**Application by Highways England for the A1 in Northumberland: Morpeth to Ellingham  
The Examining Authority's written questions and requests for information (ExQ2)  
Issued on 19 March 2021.**

**Responses are due by Deadline 5: 1 April 2021.**

Revision: P02

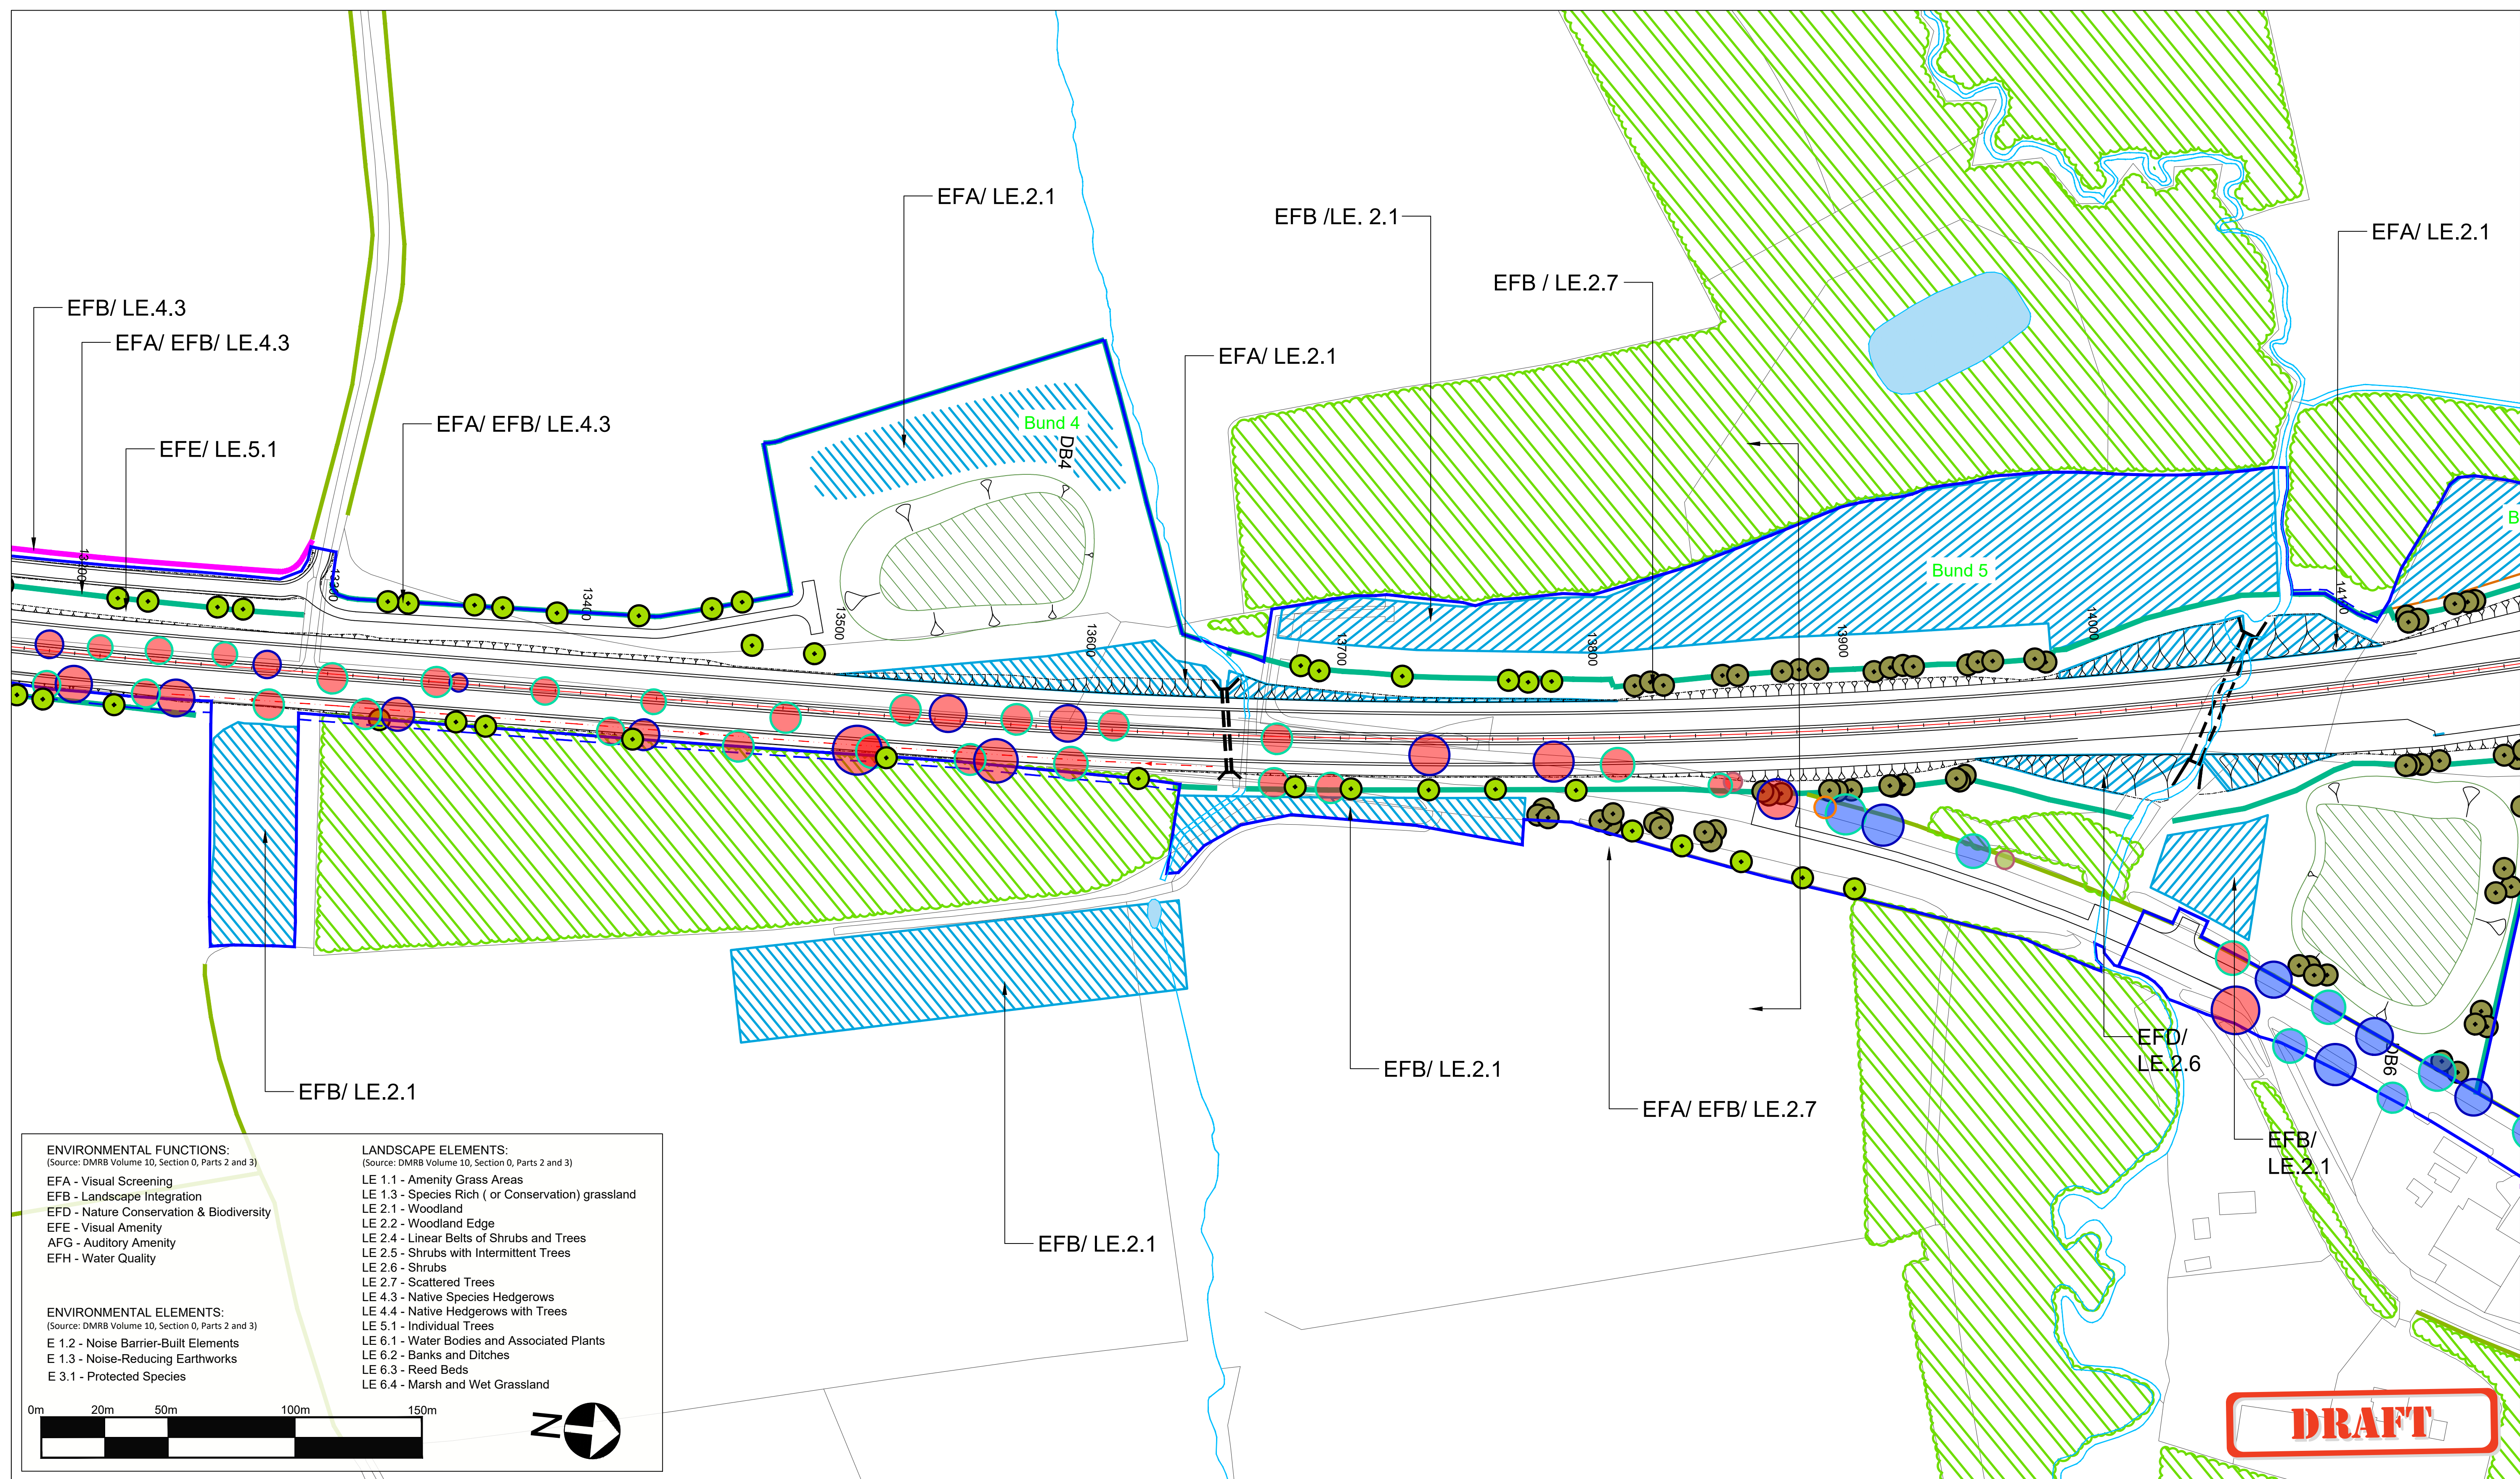
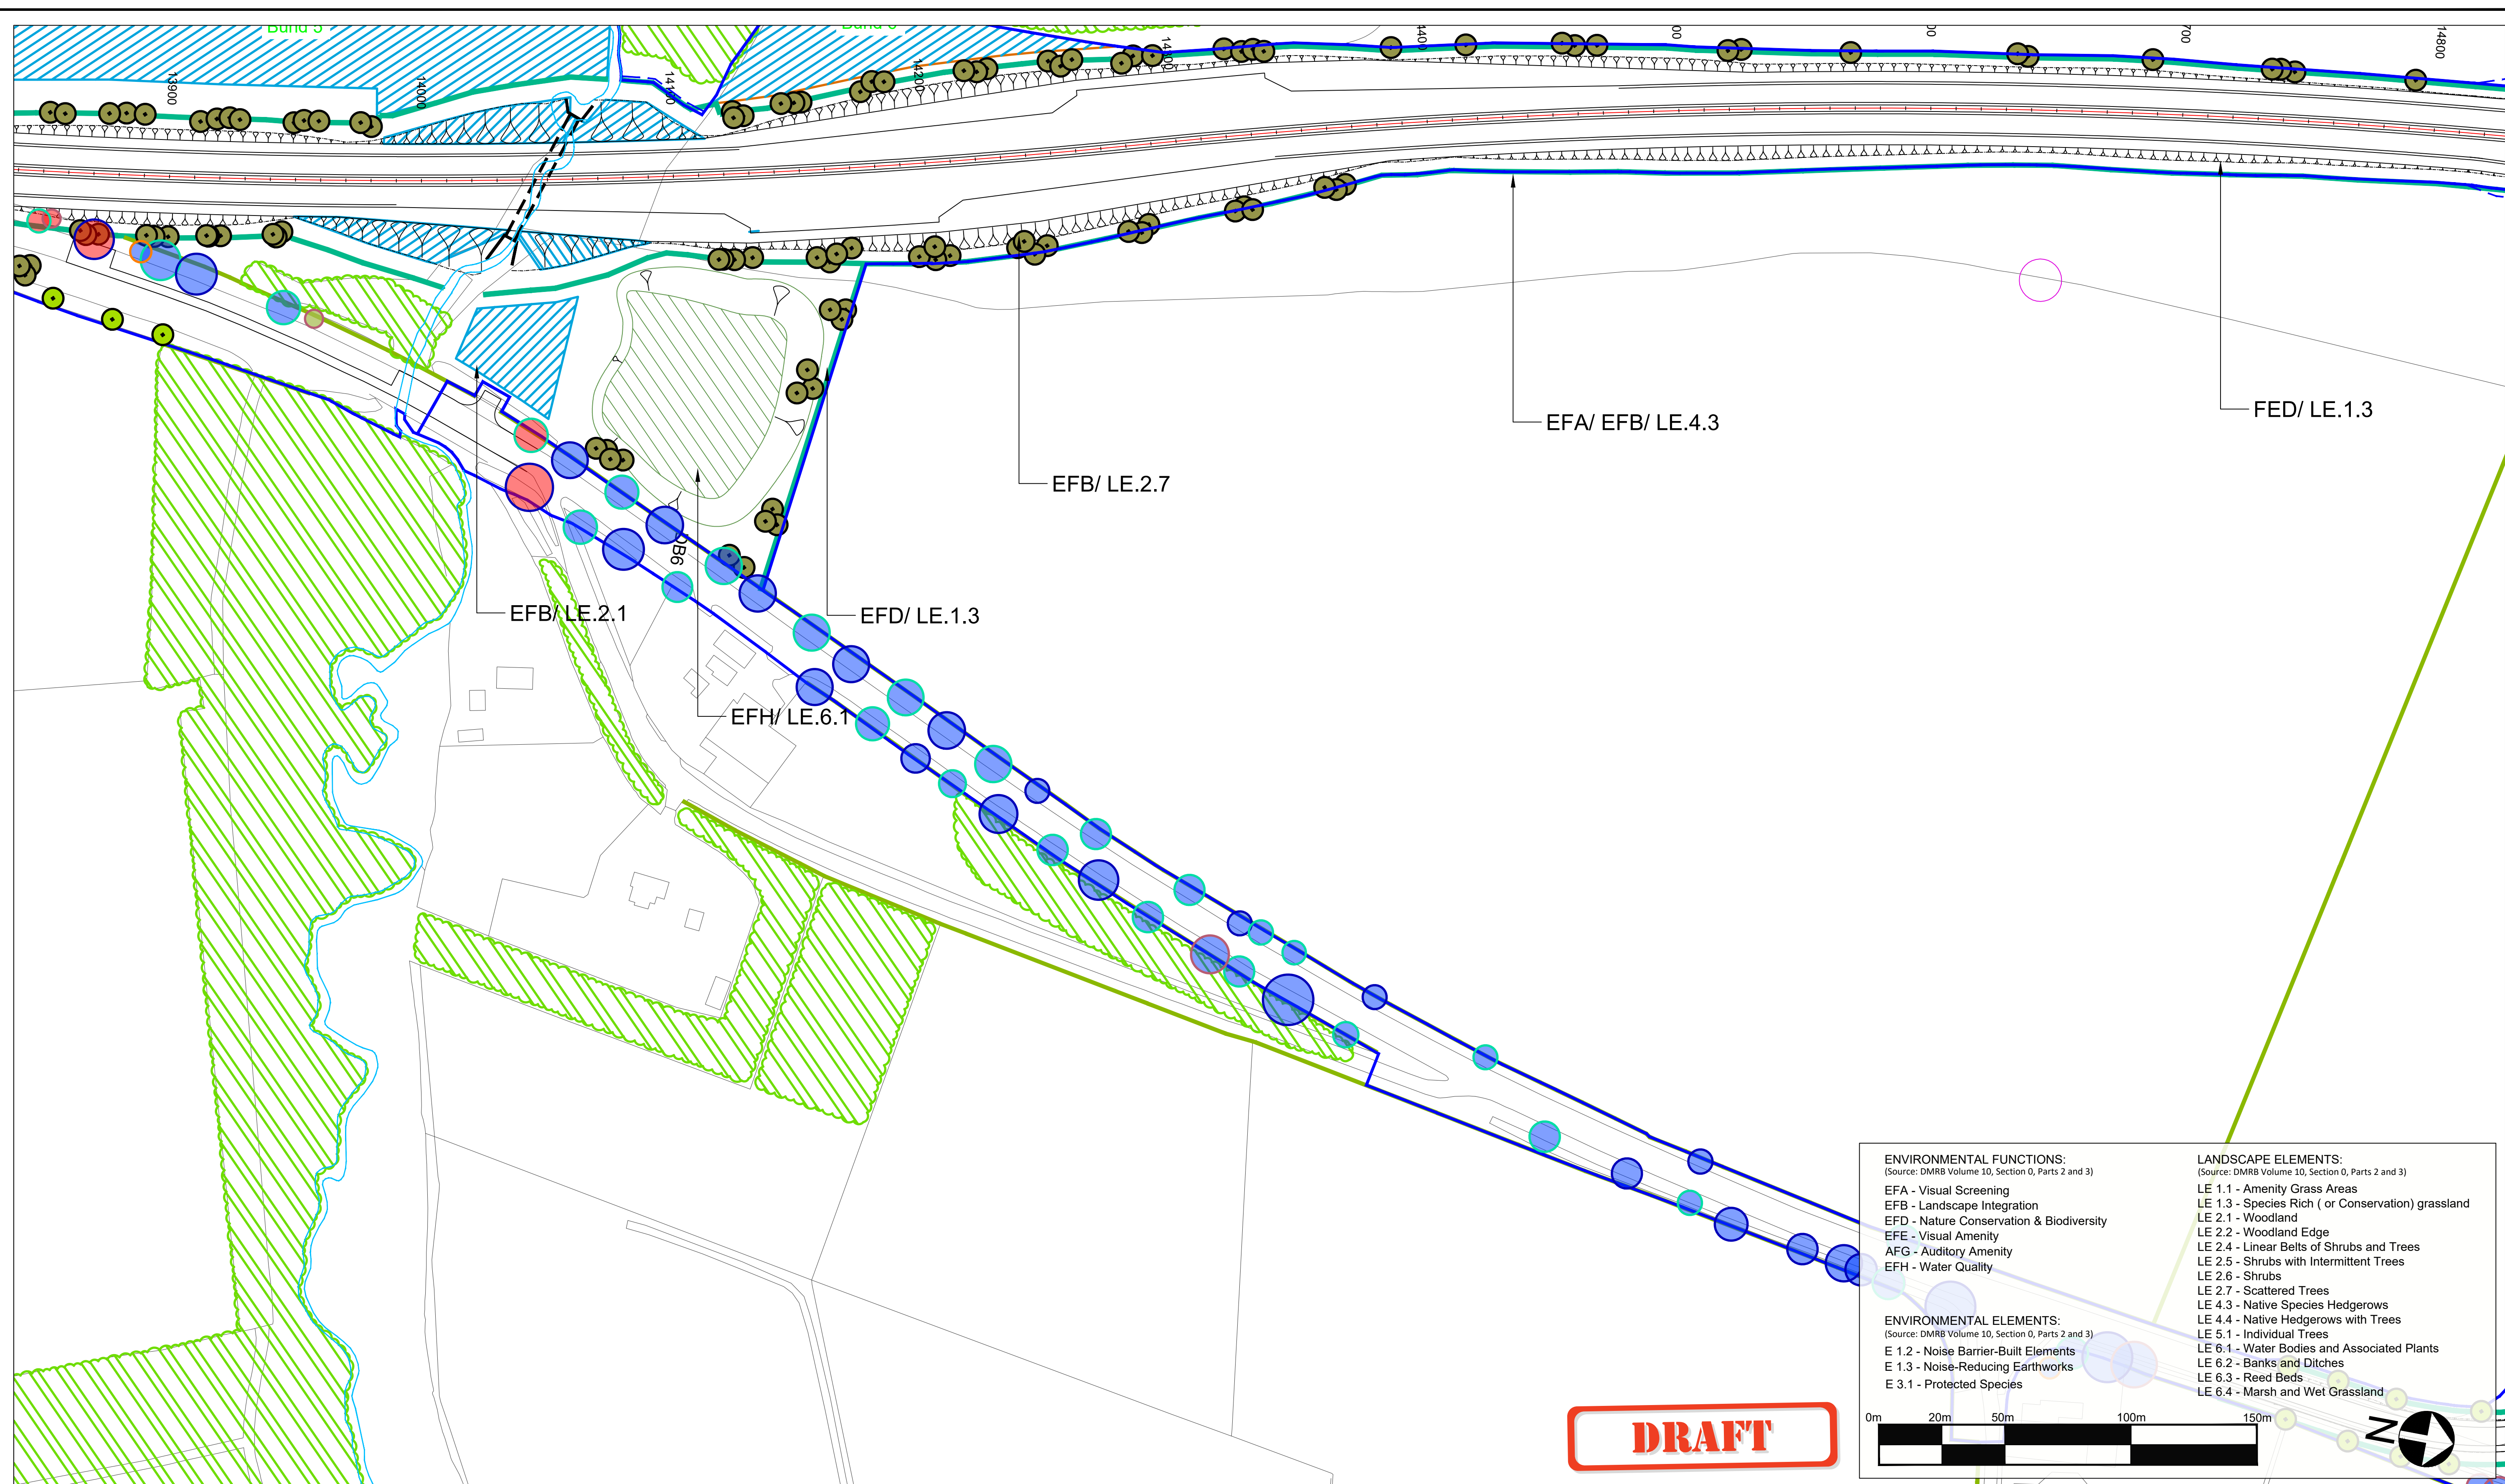
LV.2.2	Applicant IPs	The plans which form Appendix LV.2 Trees to be Removed and Replaced at Coronation Avenue WQ LV.1.8 [REP1-044] are annotated 'Draft'. The Applicant is asked to explain how this relates to the requirement in R5(3) of the dDCO for the landscaping scheme to include a strategy for the replacement of trees which are to be removed at Coronation Avenue? IPs are asked to comment on the proposals for Coronation Avenue.
